### RE: Strole Agricultural Short Plat (SP-15-00009)

The Kittitas County Community Development Services Department has determined that the Strole Agricultural Short Plat (SP-15-00009) is a complete application and hereby grants *conditional preliminary approval* subject to the following conditions:

STROLE AG SHORT PLAT SS - XX-XX
PREPARED FOR
JEFF STROLE
A PORTION OF THE W 1/2 OF SECTION 35,
TOWNSHIP 19 N., RANGE 18 E., W.M.

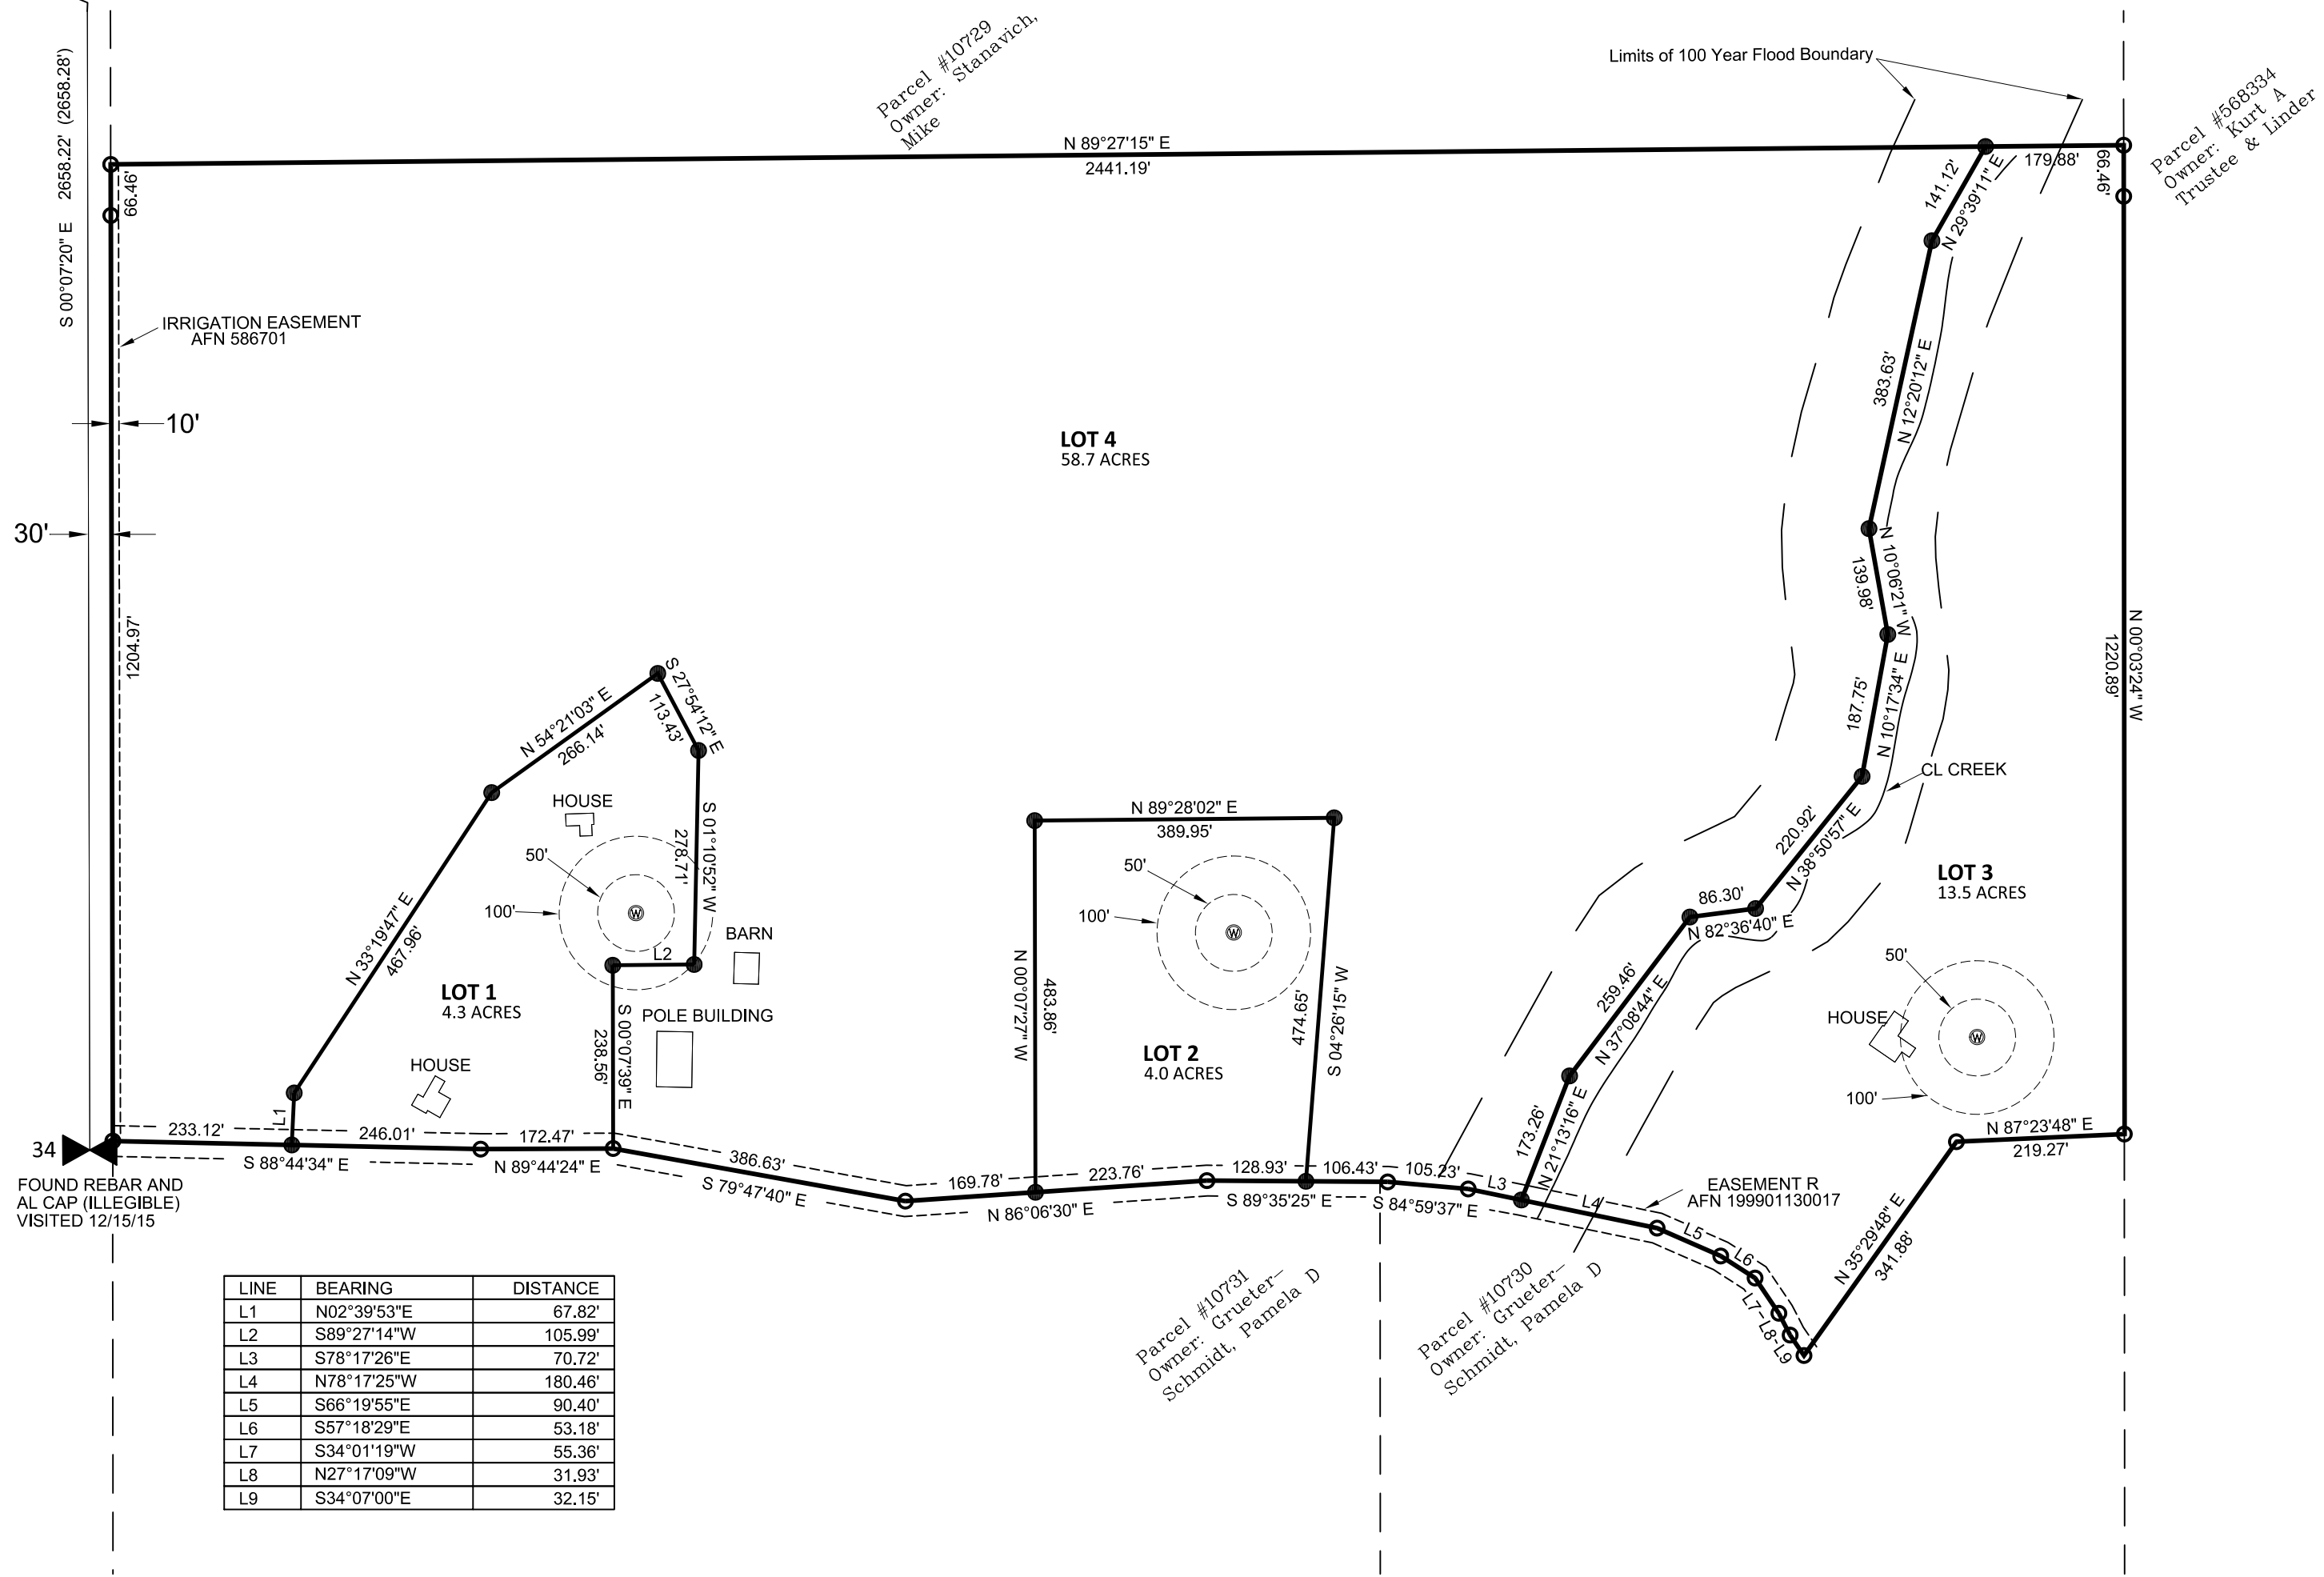
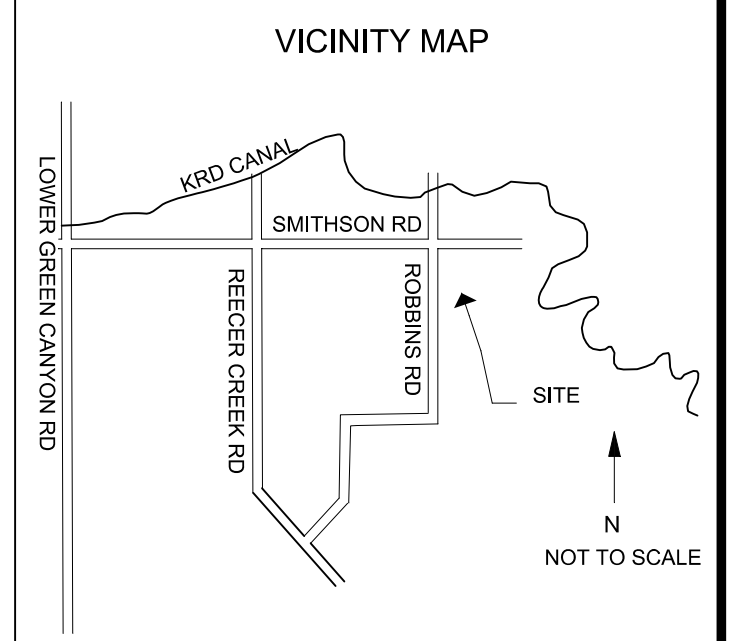
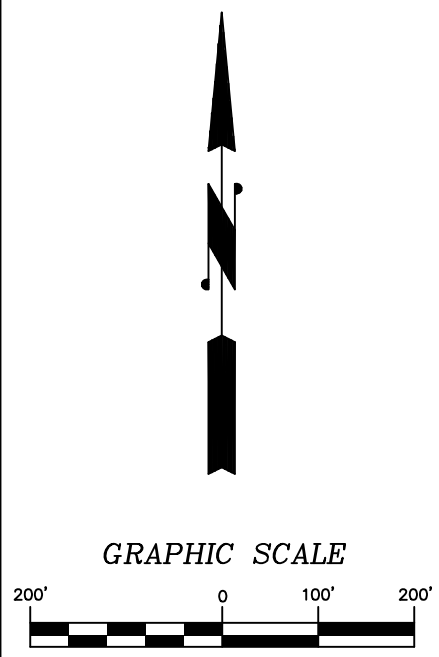
1. Both sheets of the final mylars shall reflect short plat number SP-15-00009 and an accurate legal description shall be shown on the face of the final plat. Engineers and Surveyors need to be cognizant of all of the requirements related to Final Plats (KCC 16.20) and Survey Data and Dedications (KCC 16.24). The final plat must be submitted in full conformance with these chapters of Kittitas County Code; **non-compliant mylars will be rejected and returned to the applicant.**

4. All Floodplain and wetlands shall be delineated on the face of the final mylar.
  5. Should ground disturbing or other activities related to the proposed short plat result in the inadvertent discovery of cultural or archaeological materials, work shall be stopped in the immediate area and contact be made with the Washington State DAHP. Work shall remain suspended until the find is assessed and appropriate consultation is conducted. Should human remains be inadvertently discovered, as dictated by Washington State RCW 27.44.055, work shall be immediately halted in the area and contact made with the coroner and local law enforcement in the most expeditious manner possible.
